## DEVELOPMENT SERVICES GROUP

April 4, 2017

RE: **Small Cell ROW Use Permit Application(s)**  
Second Request for Additional Information – MIS01 through MIS24 and MIN01 through MIN15

Alternate Site Analysis MIS12

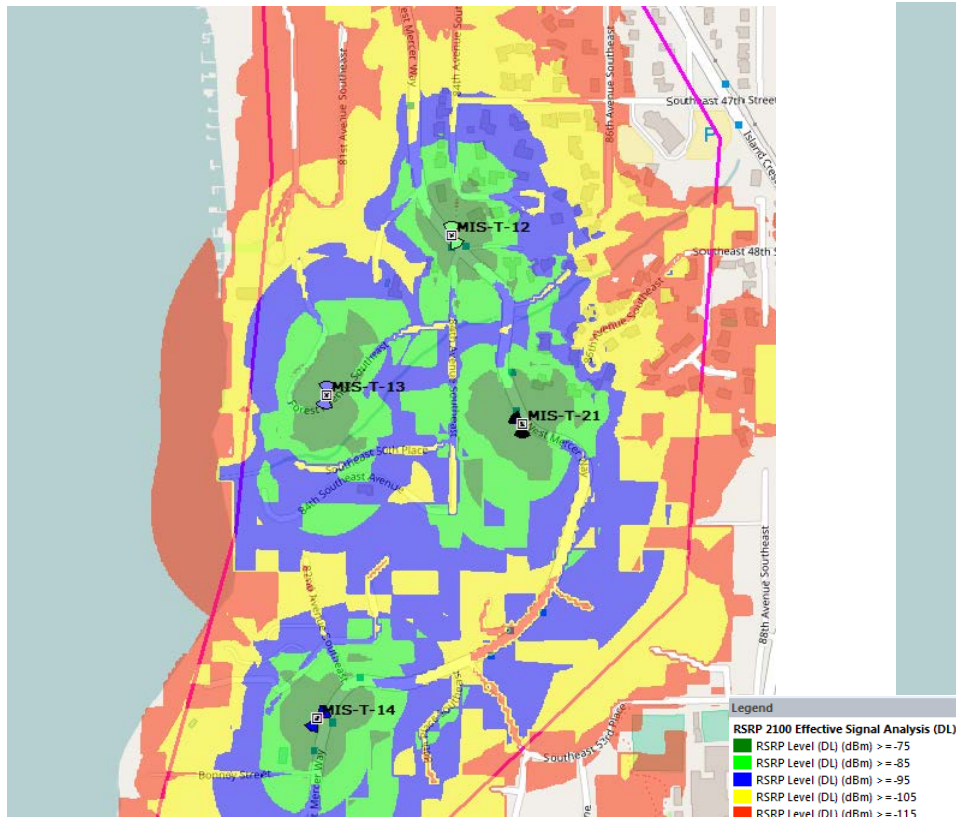
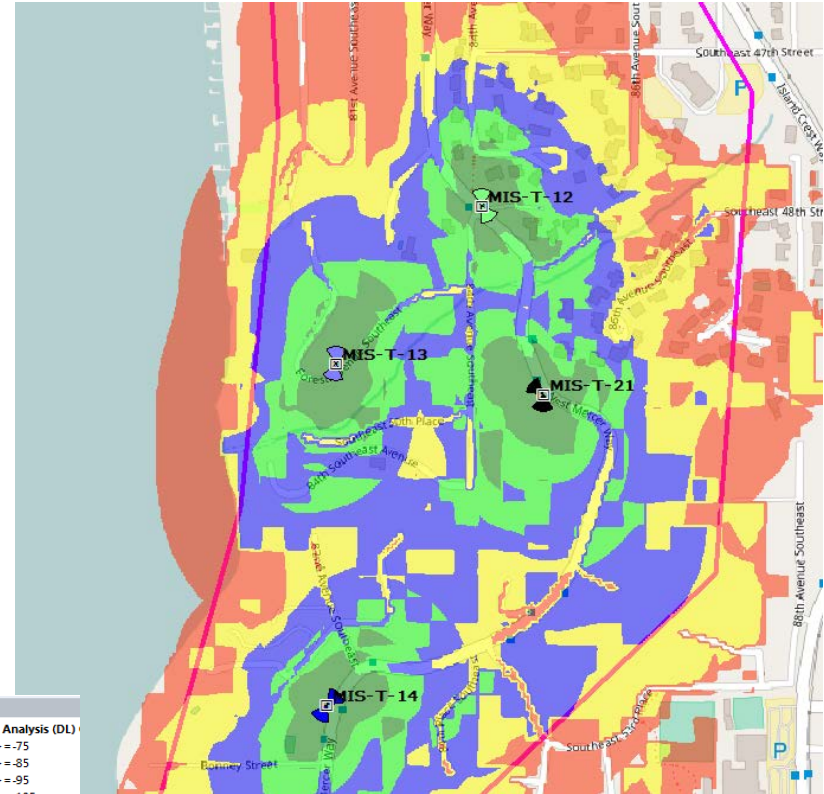
5. MIS 12. The response to MIS 12 asserts that alternative location #4 is located on private property. Maps available to city staff indicated alternative location #4 is located in the public right of way. Please provide a basis for the assertion that this pole is located on private property.
